February 28, 2023

JN 22007

Subject: **Review of Plans and Response to Geotechnical Review Comments**
Proposed New Residence
6950 Southeast Maker Street
Mercer Island, Washington

Reference: Geotechnical Engineering Study, same project; Geotech Consultants, Inc.; March 21, 2022.

**C-2**

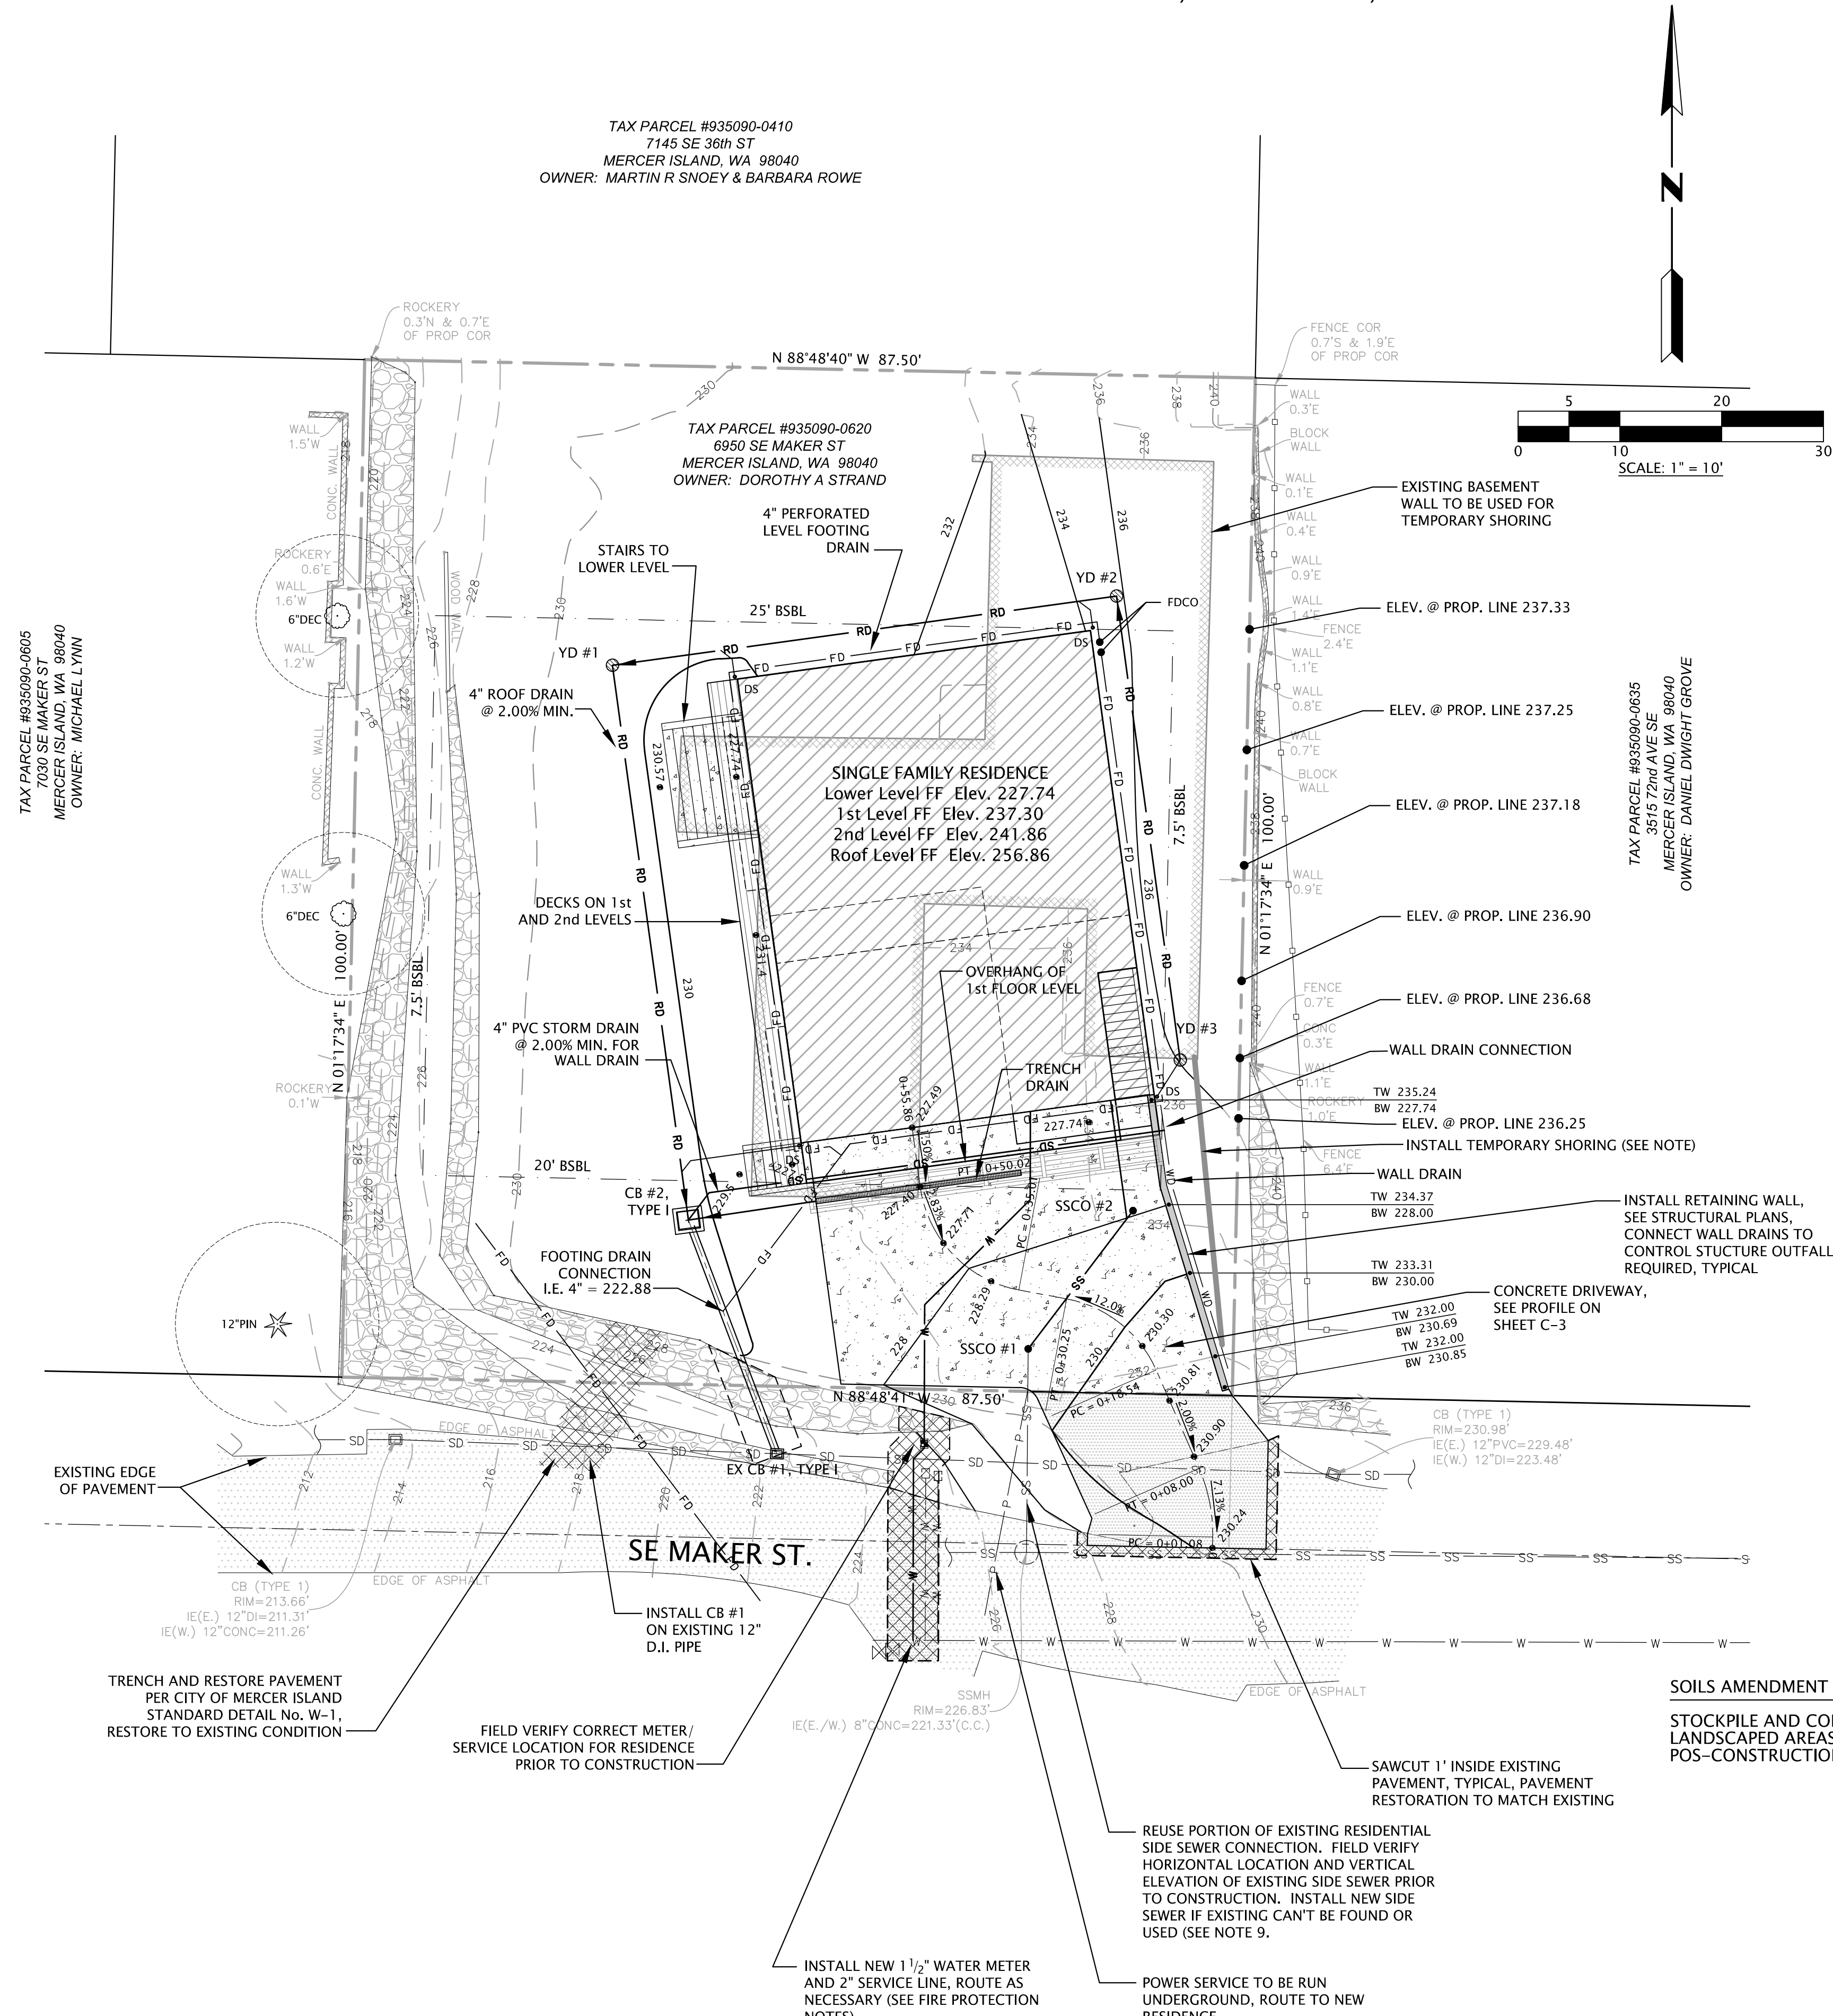
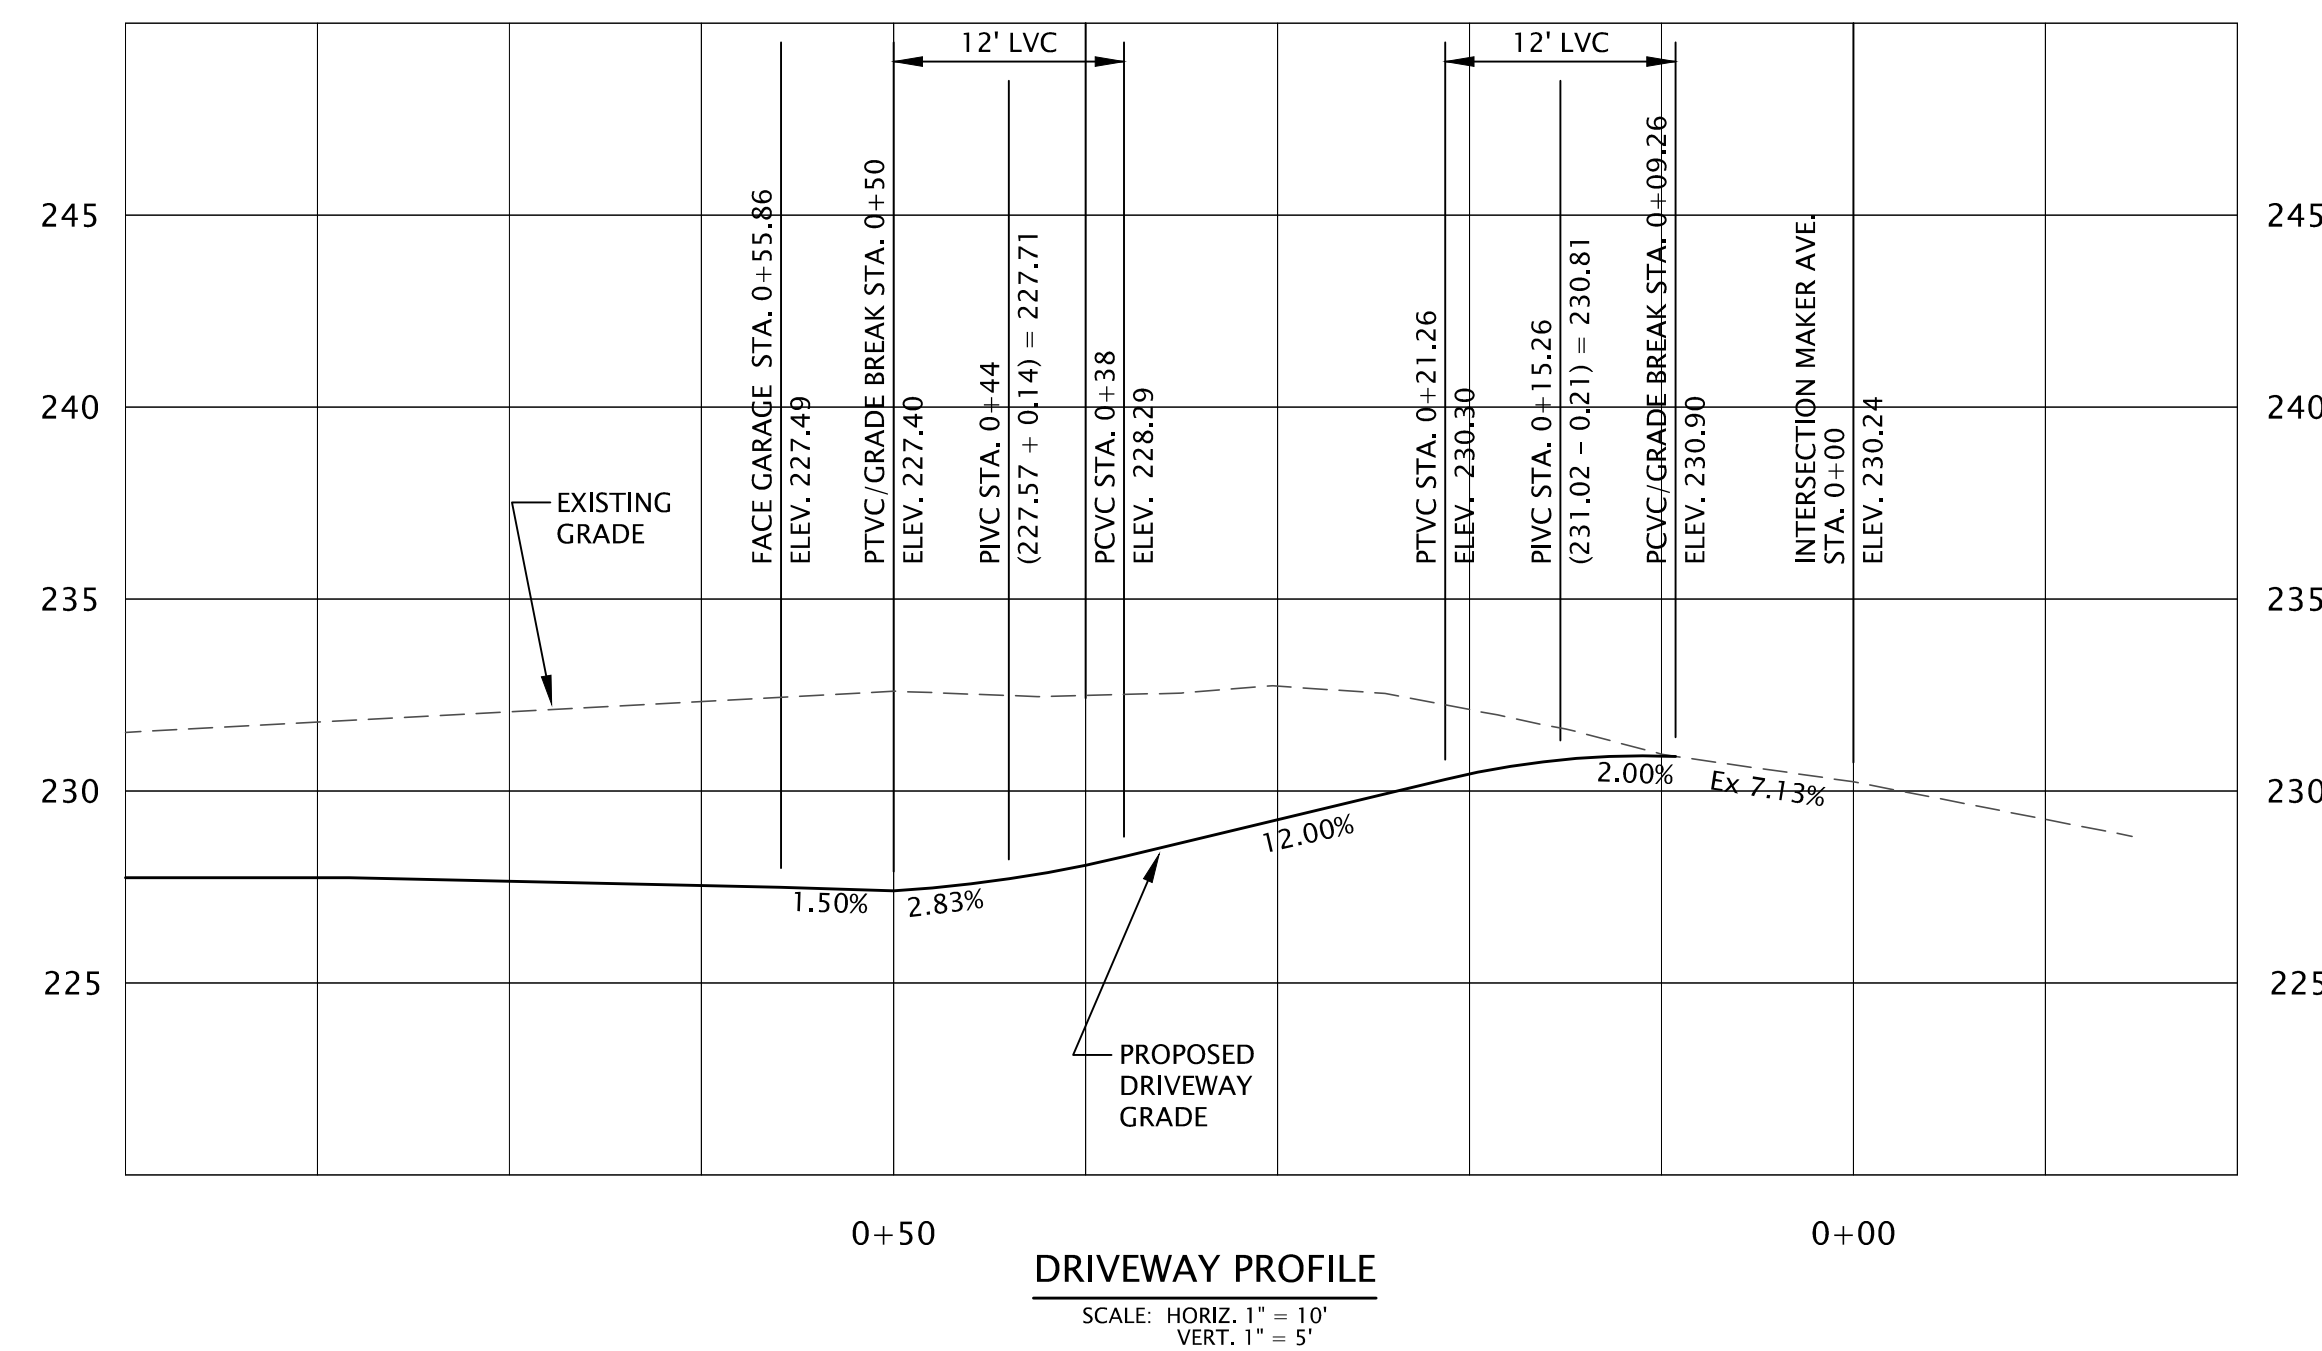
The foundations for the new residence will bear on dense glacial till soils. Cantilever soldier pile shoring has been incorporated along the eastern, upslope, side of the excavation for the driveway and the southern portion of the house. The soldier piles along the driveway, to the south of the house, will be faced with concrete and will provide permanent support. The existing basement wall of the current house will remain in place to provide excavation shoring north of the soldier piles. The excavation shoring is shown on sheets SH1, SH2, and C-2.

As depicted on sheets C-2 and C-3, the eastern basement wall of the new house will be backfilled to provide permanent lateral support, with the backfill sloping up to the face of the lower wall located at the eastern property line. This is intended to provide appropriate permanent stability for that wall.

A new storm drain will be installed to the west of the house, extending southward to Southeast Maker Street. In order to install this storm drain, a section of the 4-foot rockery located along the southern edge of the lot will have to be removed and be rebuilt. This is illustrated on sheets C-2 and C-3. Removal and proper reconstruction of this small section of rockery will not adversely affect stability of the site or neighboring properties.
